From: [Kit Woods](#)
To: [CDS User](#); [Jamey Ayling](#)
Subject: Fowler Creek Guest Ranch (CU-23-00003)
Date: Saturday, October 7, 2023 12:16:28 PM

RE: CDS CU 23-00003

Opposition Comments to Fowler Creek Guest Ranch Proposal

EXHIBIT 16 - SITE PLAN - FOWLER CREEK GUEST RANCH

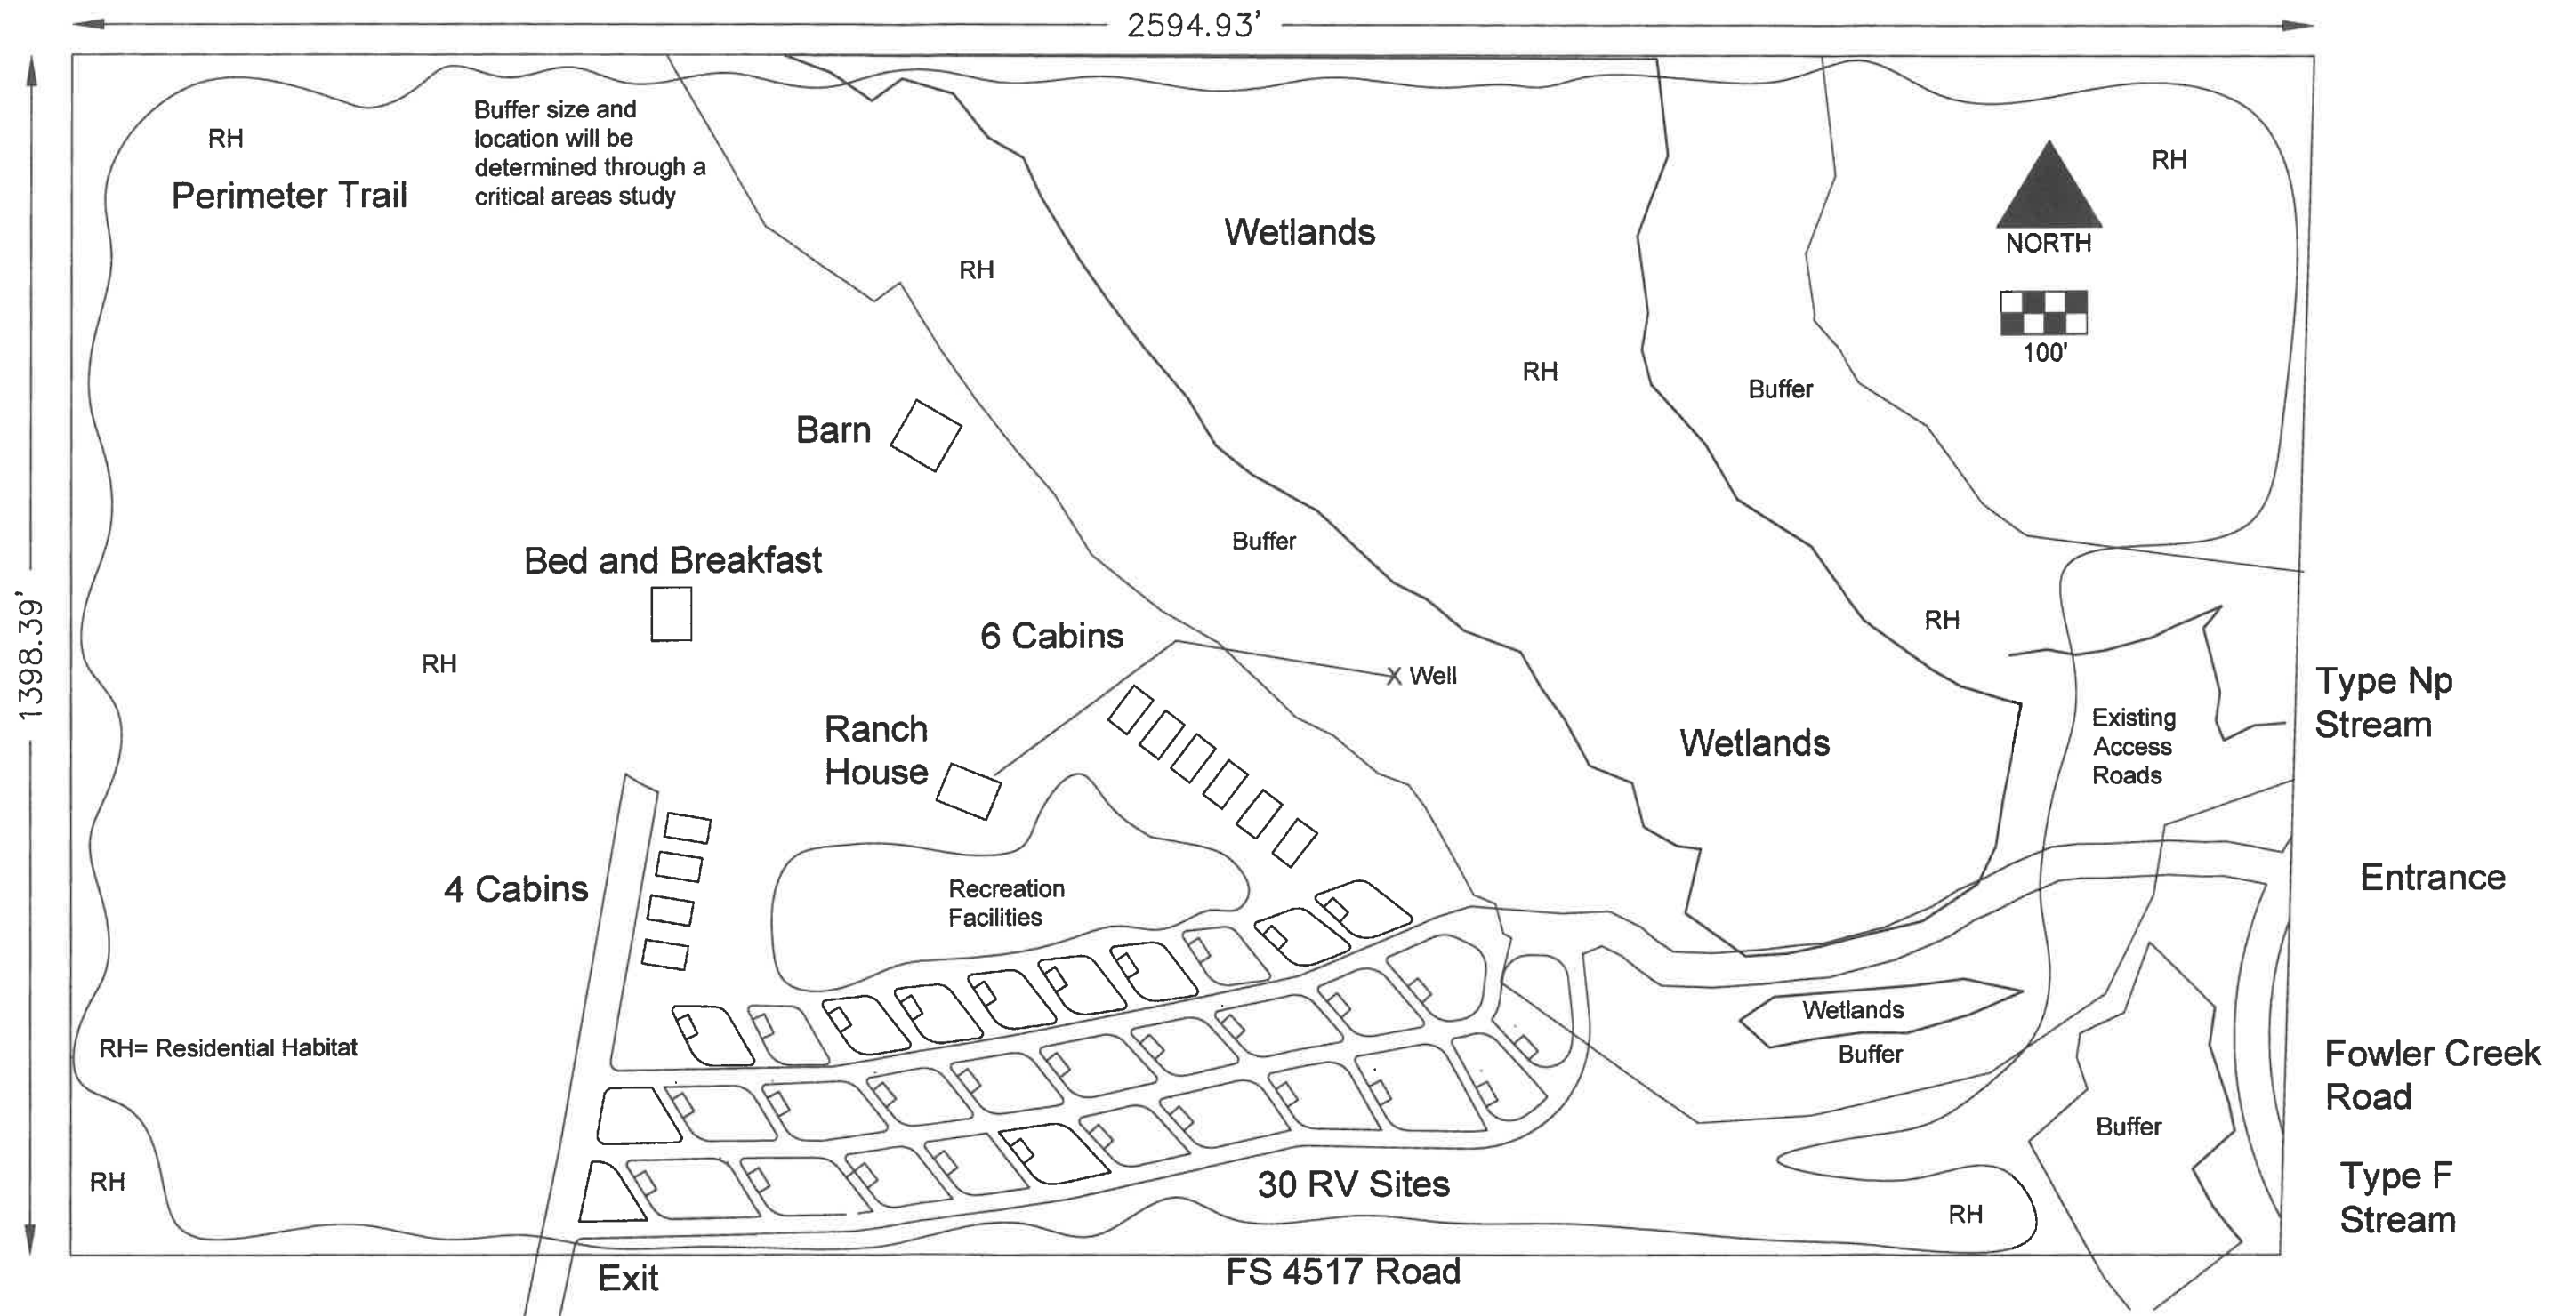
<!--[if !supportLists]--> <!--[endif]-->**Traffic concerns** are practically disregarded, neglecting to mention the heavy burden on Fowler Creek Road. The Site Plan shows an exit onto FS4517 Rd which will take the traffic directly back to Fowler Creek Rd, seemingly an attempt to circumvent the heavy use requirement that stopped another proposed large project further up the way.

<!--[if !supportLists]--> <!--[endif]-->**Wetlands** are to be treasured and protected as they serve to enhance the available water supply, especially headland wetlands. The Department of Ecology definitely needs to be consulted. According to Exhibit 16 - Site Plan included in the materials I received, RH (Residential Habitats) are dotted around in the project buffer zones as well as the noted Wetlands. This needs deep consideration, particularly with regard to waste water contamination and down-stream requirements for the dwindling supply of the total water resource.
